Our Ref: K/51/20/NMA

Non material amendment following grant of ref K/26/19/HH for the removal of ground floor extension and stone cladding to existing porch wall.

105 Golden Avenue East Preston BN16 1QT

Drawing P01a September 2019 Scale 1:100 @ A3
Planning Drawing - Ground Floor Plan and Elevations

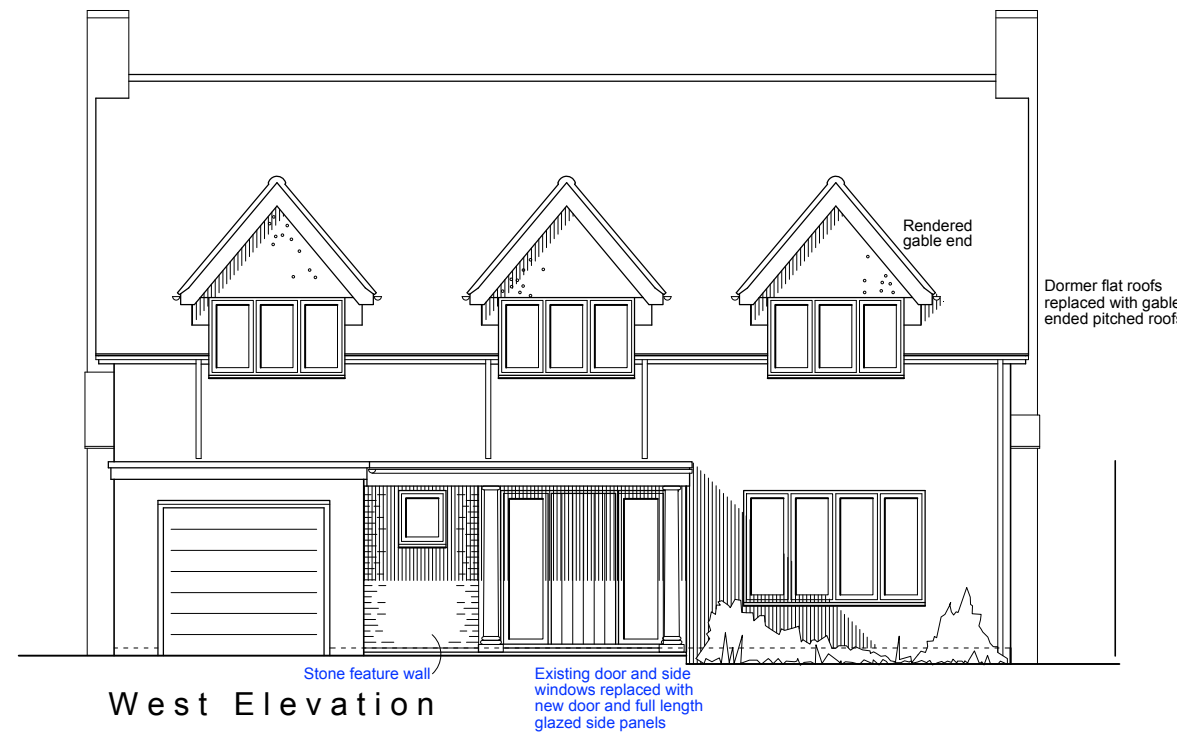
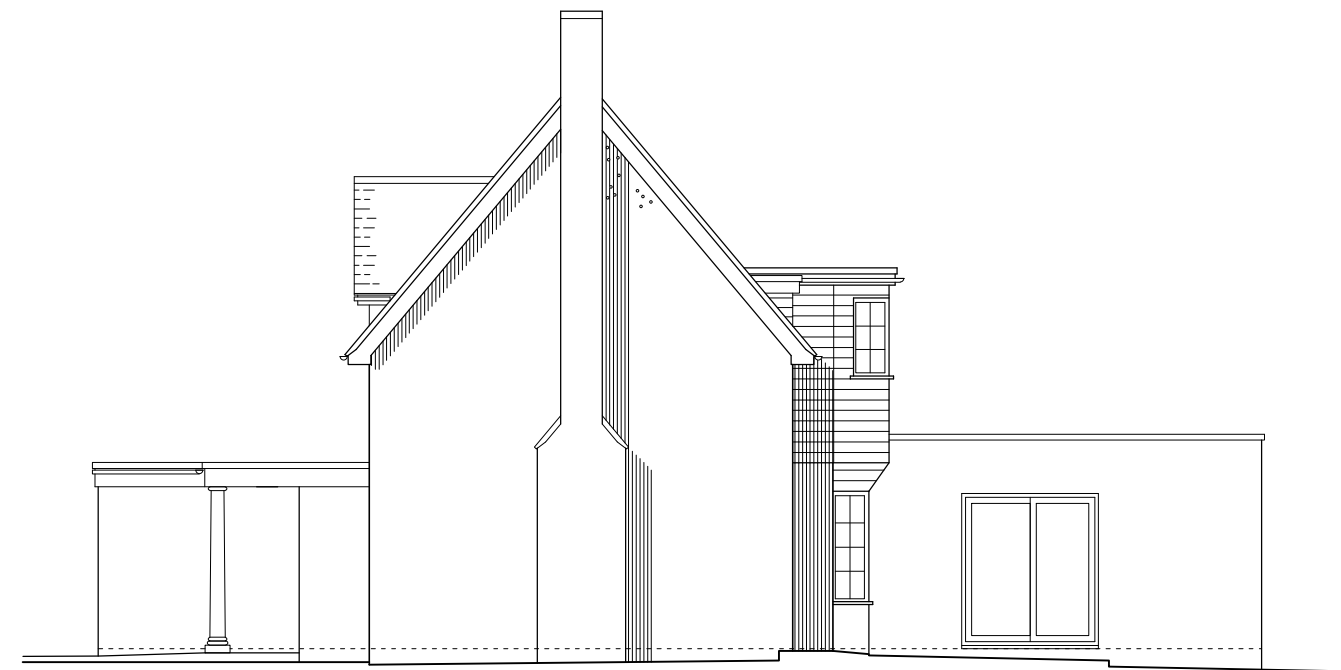
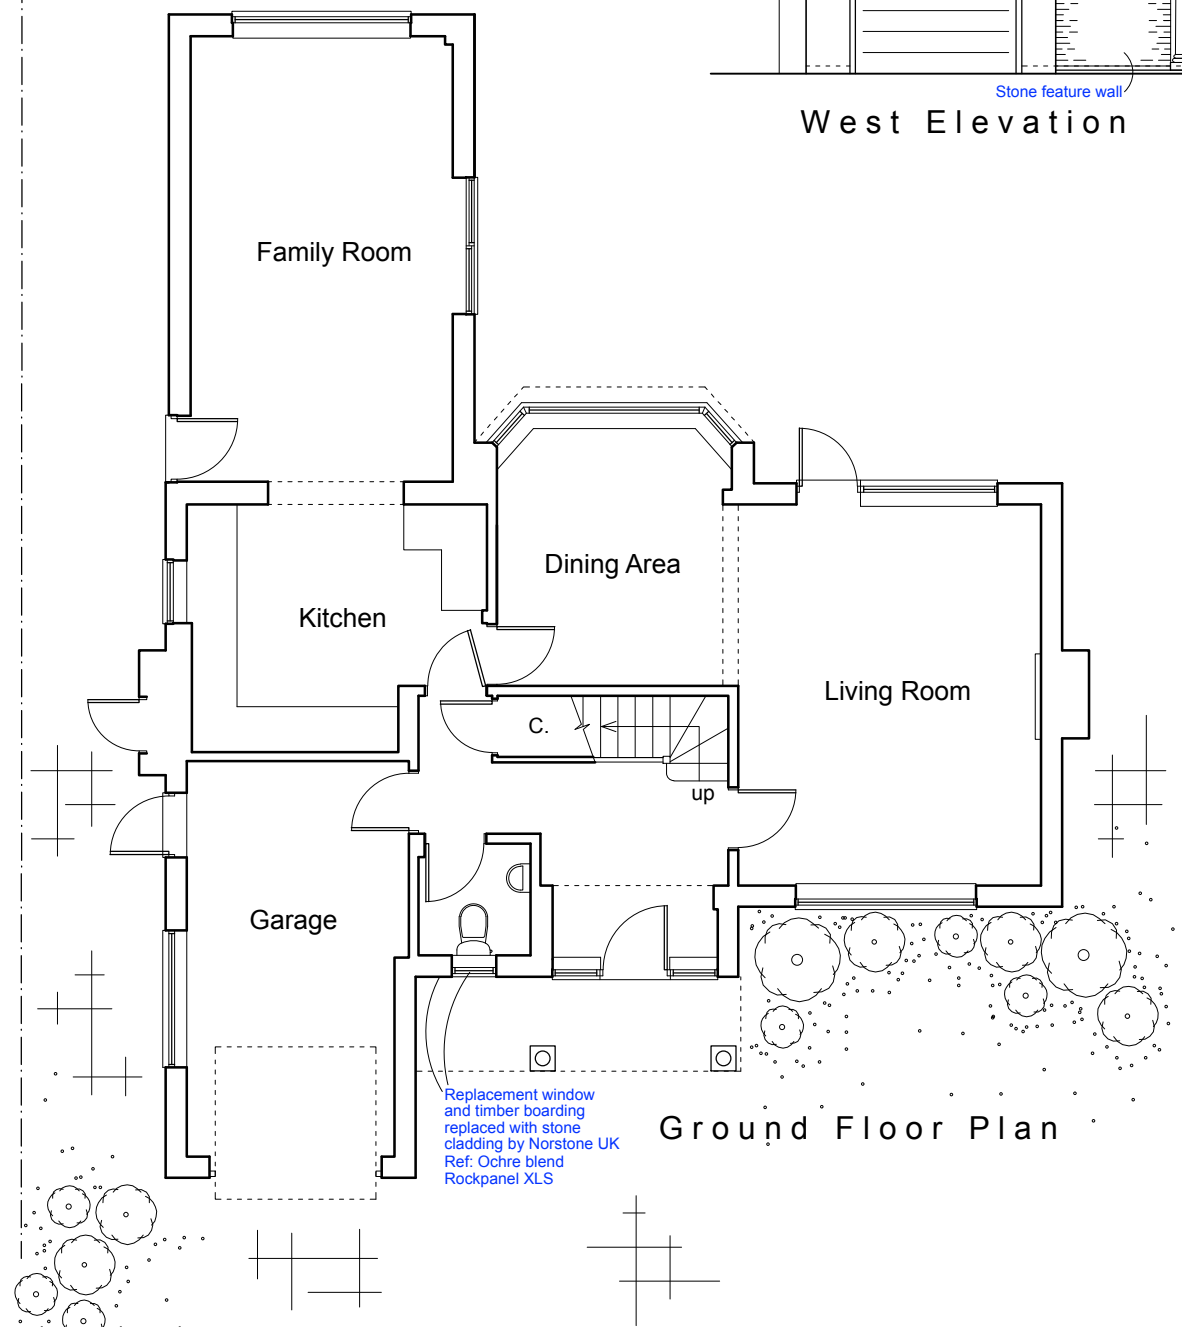
I refer to your recent application for a Non Material Minor Amendment. I note that you seek to remove a ground floor extension element, and the stone cladding of the porch wall.

Please note that plans references 'Planning Drawing - Ground Floor Plans and Elevations - Drawing P01 - September 2019' and 'Planning Drawing - Roof, Location & Block Plans & Elevation - Drawing P02 - September 2019' are hereby replaced by 'Planning Drawing - Ground Floor Plan and Elevations - P01a - September 2019' and 'Planning Drawing - Roof, Location & Block Plans & Elevation - P02a - September 2019'.
